**Consultation Response from KC,  
Highways Development Management**

**2024/90425 land south of, Swallow Lane, Golcar, Huddersfield, HD7 4NB**

**Discharge of conditions 3 (CEMP), 4 (CMP), 5 – 7 (Ground Investigations), 9 (road specification), 10 (footway specification), 11 (road condition survey), 12 (surface water drainage strategy), 13 (construction phase drainage strategy), 14 (arb method statement) and 15 (invasive non-native species protocol) on previous permission 2020/94096 for erection of 21 dwellings and associated works**

**Date Responded:18-2-2024.**

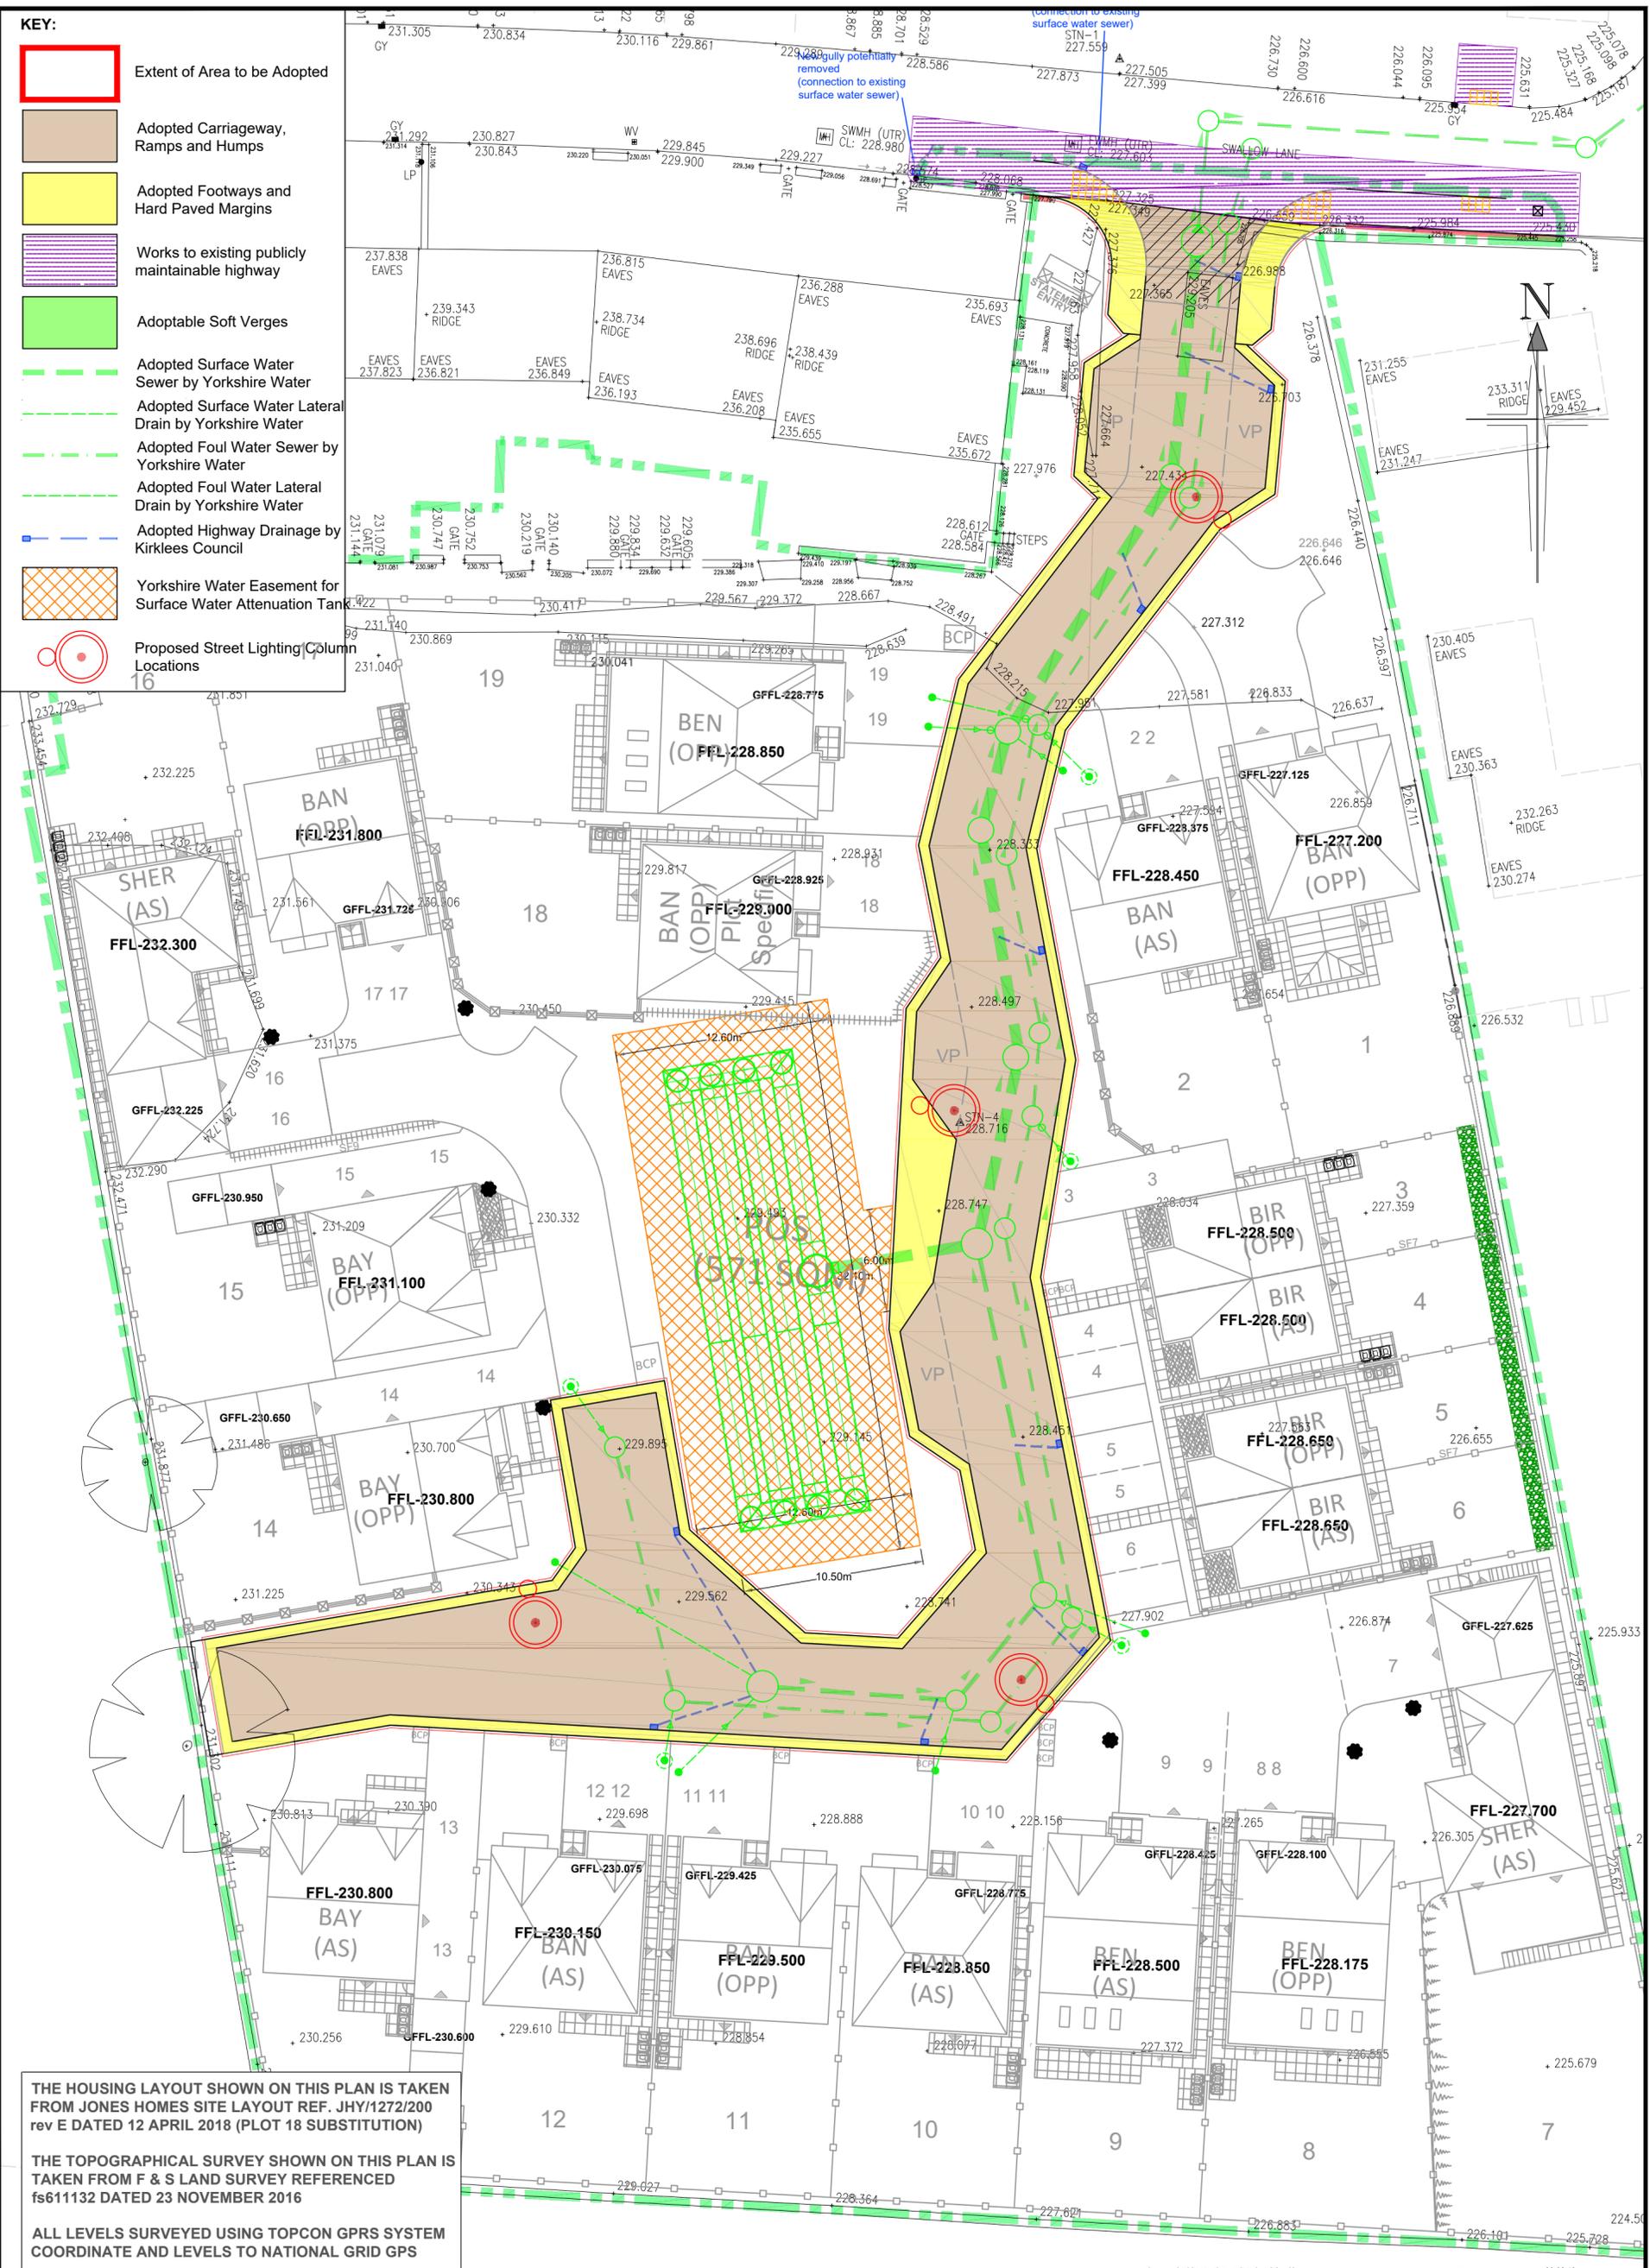
These proposals (internal adoptable estate roads and footway) will require a separate formal Technical Approval by the Council's Highways Section 38 Team. The council's Section 38 Engineer confirms that technical approval has not yet been granted for a section 38 Agreement and this condition cannot therefore be discharged.

# Golcar 2 – Photographs

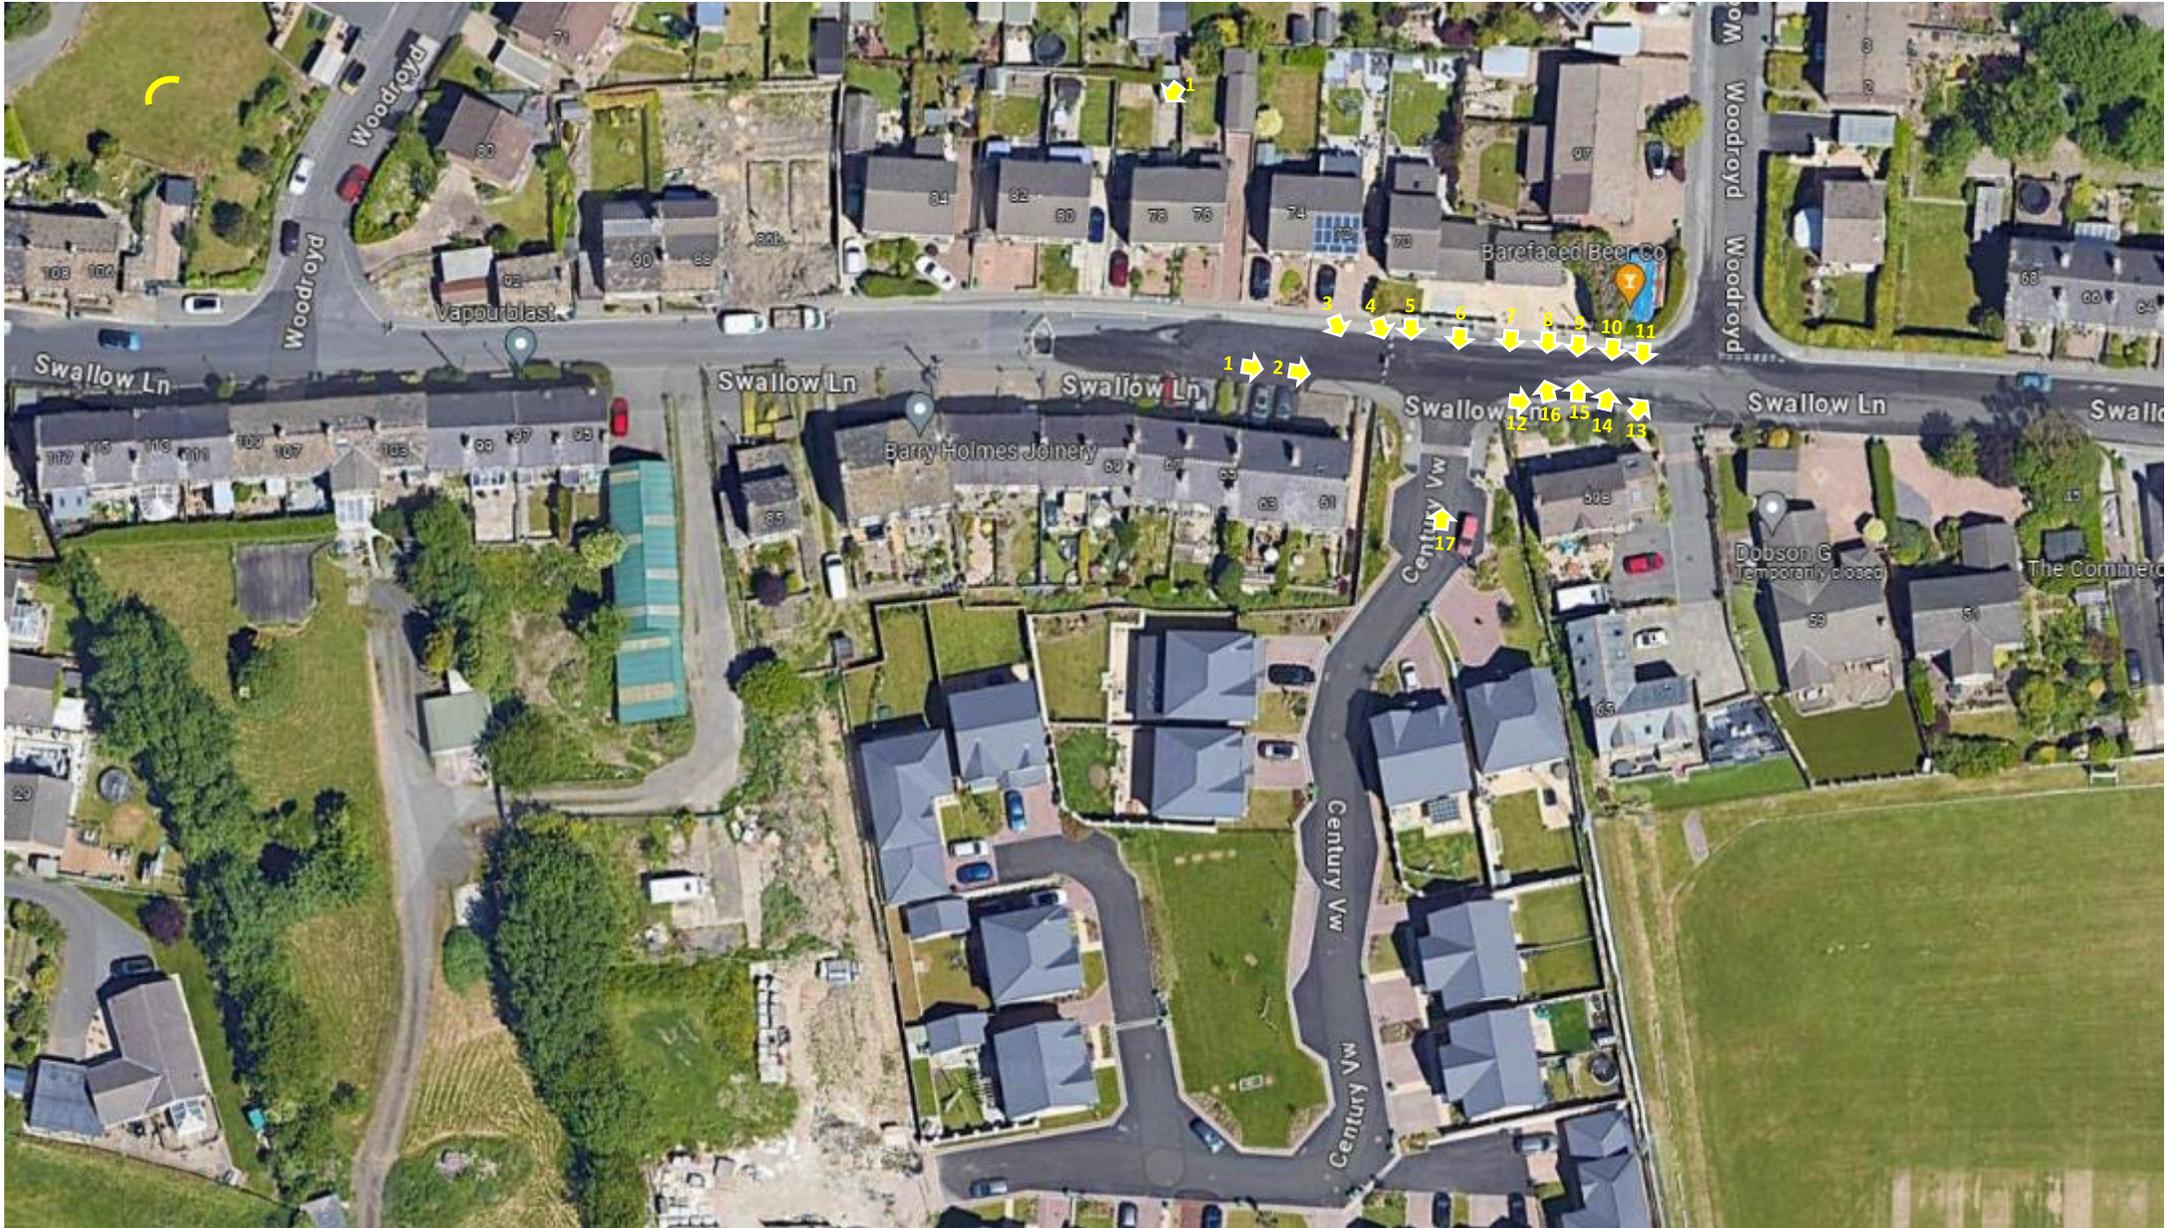
The survey provided only shows the site access from Swallow Lane and not the surrounding road network. Note Century View should also be included if it has been adopted as highway maintainable at public expense. This condition should not therefore be discharged.

Site Access off
Phase 1

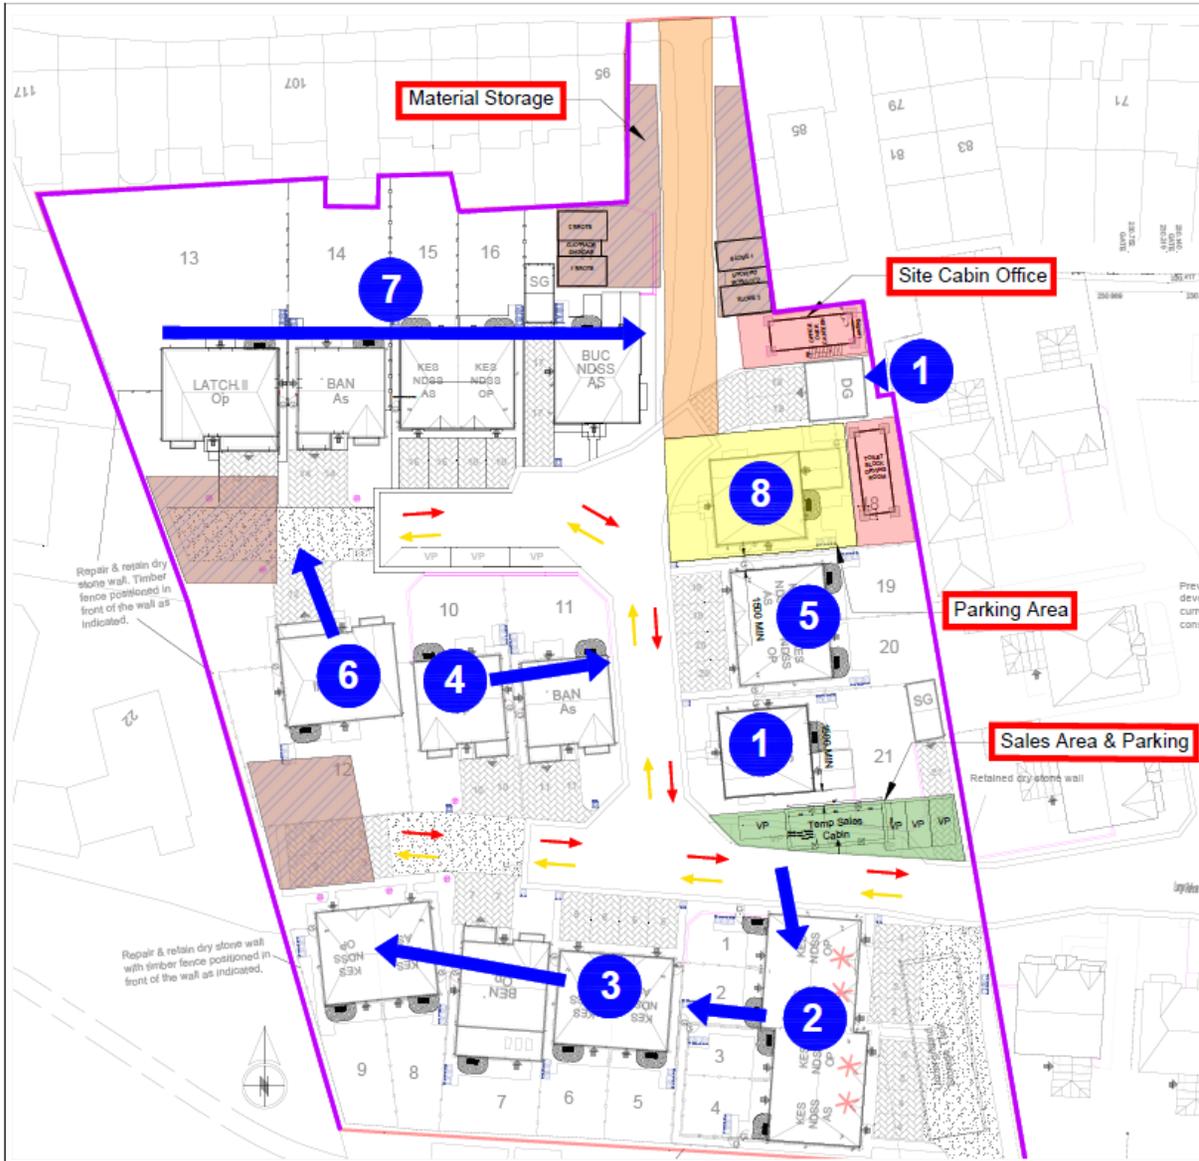
The applicants have provided an acceptable Traffic Management Plan and Highways Development Management have therefore no objection to the discharge of this condition.
